Re: Comag Site, West Drayton (LPA Ref: 24843/APP/2022/2403)- Independent Review of Daylight and Sunlight Assessment: Addendum Responses

This practice, eb7 Limited, is appointed by Bellway Homes to advise on the daylight / sunlight implications of the proposed development to the former Comag Works site, Tavistock Road, Yiewsley. The detailed findings of our assessment were submitted in a detailed Daylight / Sunlight Report dated August 2022. This addendum addresses queries raised in an Independent Review of the Daylight and Sunlight Assessment prepared by Avison Young dated October 2022.

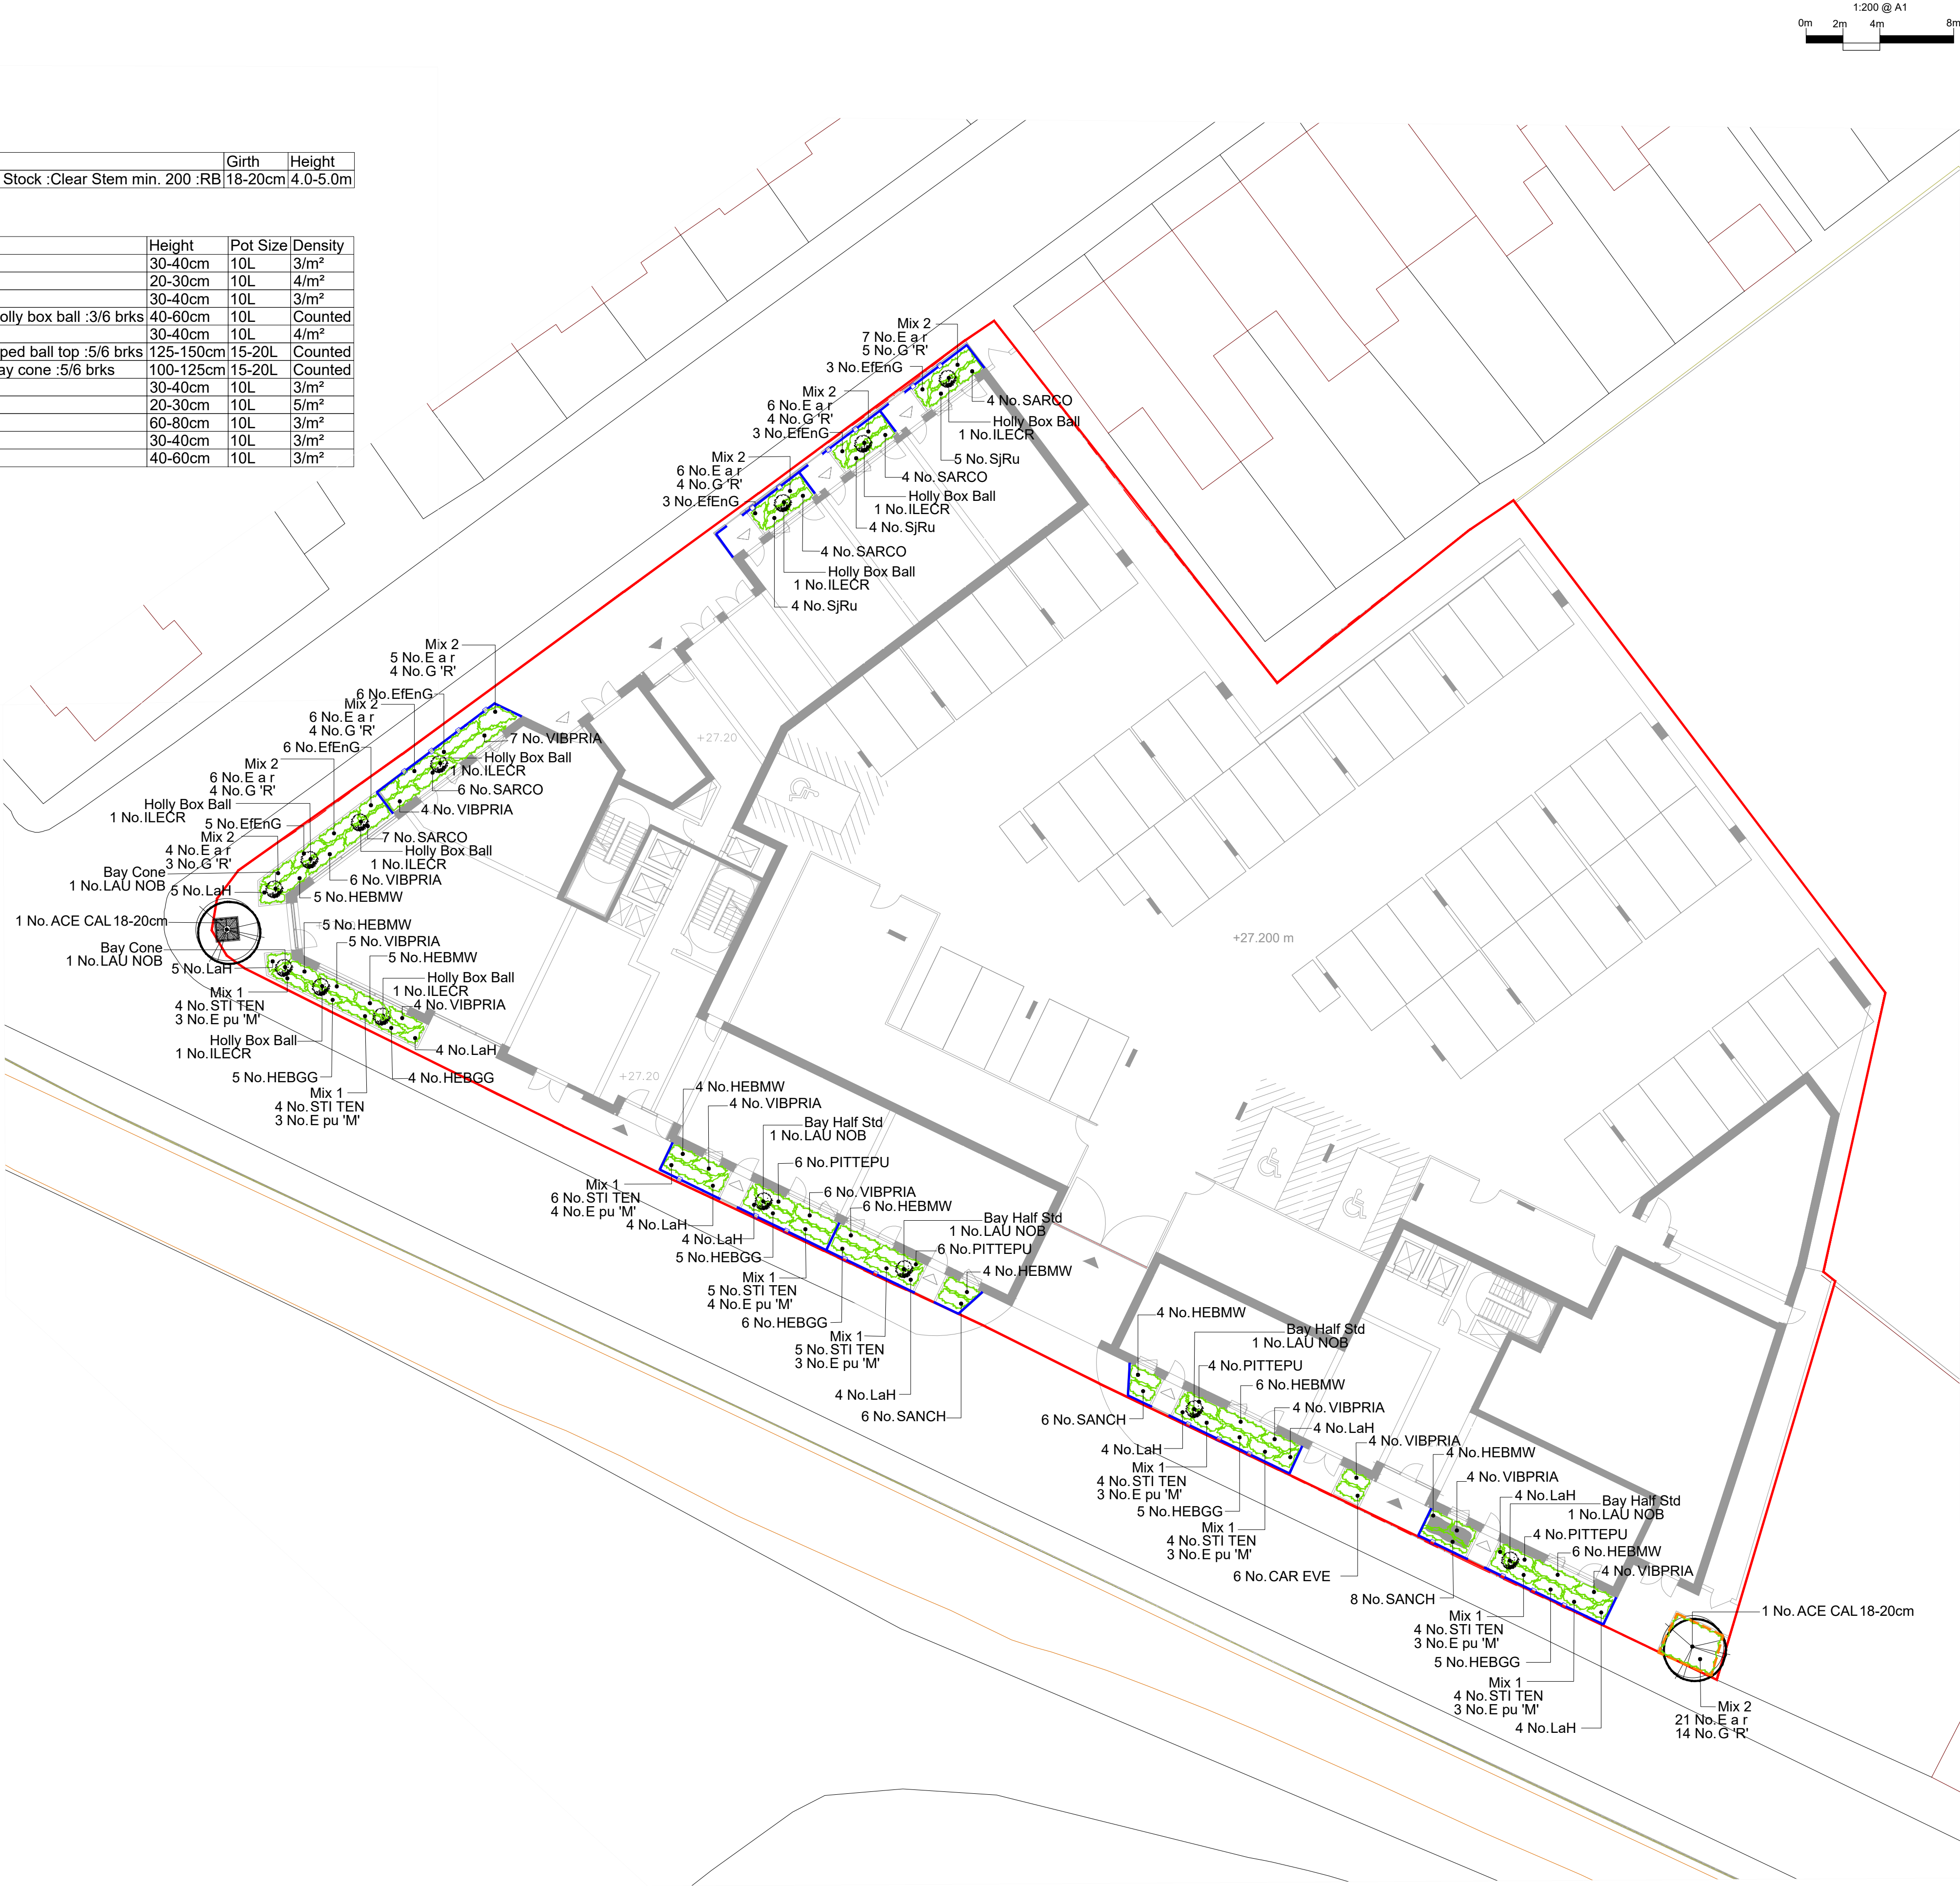
The design is stated as responding to the annual sunlight access and it can be seen that the proposed play spaces are located towards the north of the ground floor external amenity area, where they would be best sunlit throughout the year. It is unclear what the remainder of the space would be used for/ arranged.

The landscape plan is attached in appendix 6 prepared by Aspect landscape planning. This shows a combination of outdoor gym space, planting, children's play area and external seating.
